**Planning application:
21/00264/CEU**

Address: Madina Mosque 2 Stanley Road Oxford OX4 1QZ
Proposal: Application to certify that the existing single storey outbuilding is lawful development.
Case Officer: Stacey Harris

Submission from

PROPOSED EXTENSION TO EXISTING WASH ROOM AT REAR OF
 SCALE 1:50 2 STANLEY ROAD MOSQUE OXFORD

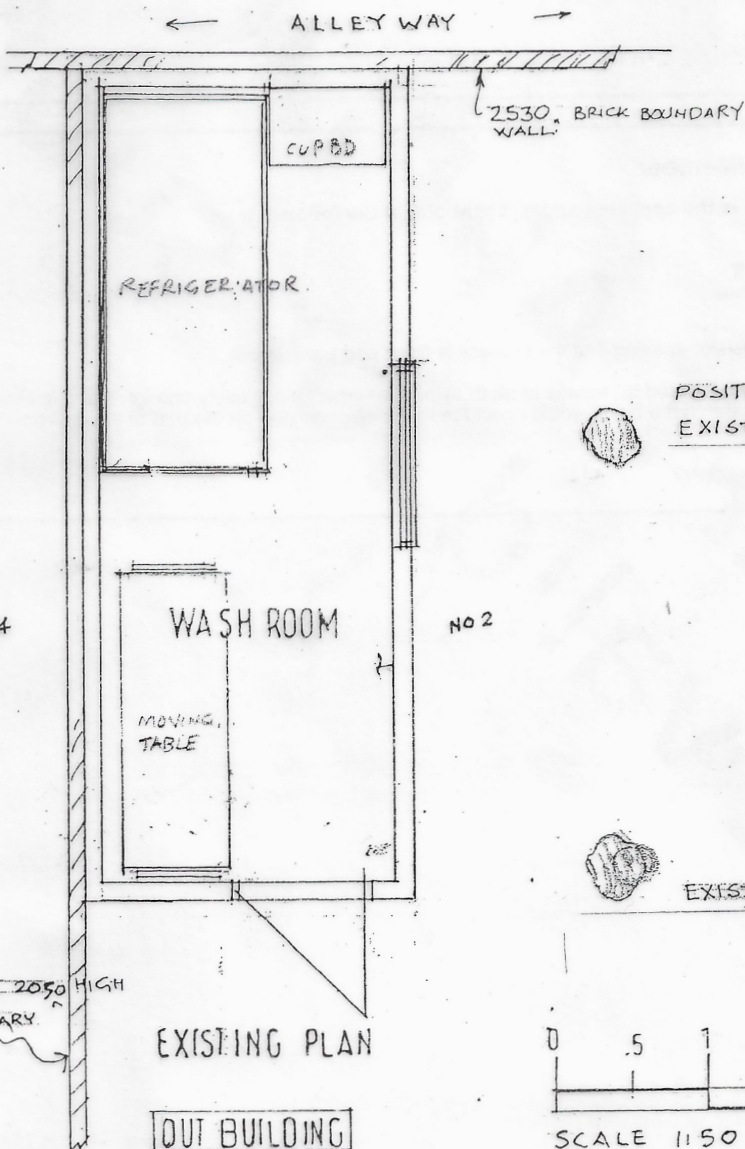
CONSTRUCTION NOTE the drawings in this and the previous application 20/02813/FUL are contradictory and ambiguous. In fact, the mortuary would seem to have only 3 (maybe 2) substantial, supporting walls, being propped up against the neighbour's brick wall (and possibly the rear lane wall).

Its roof is suspended on and overhangs the no 4 brick wall which extends all the way to the roof not half way as shown in the drawings.
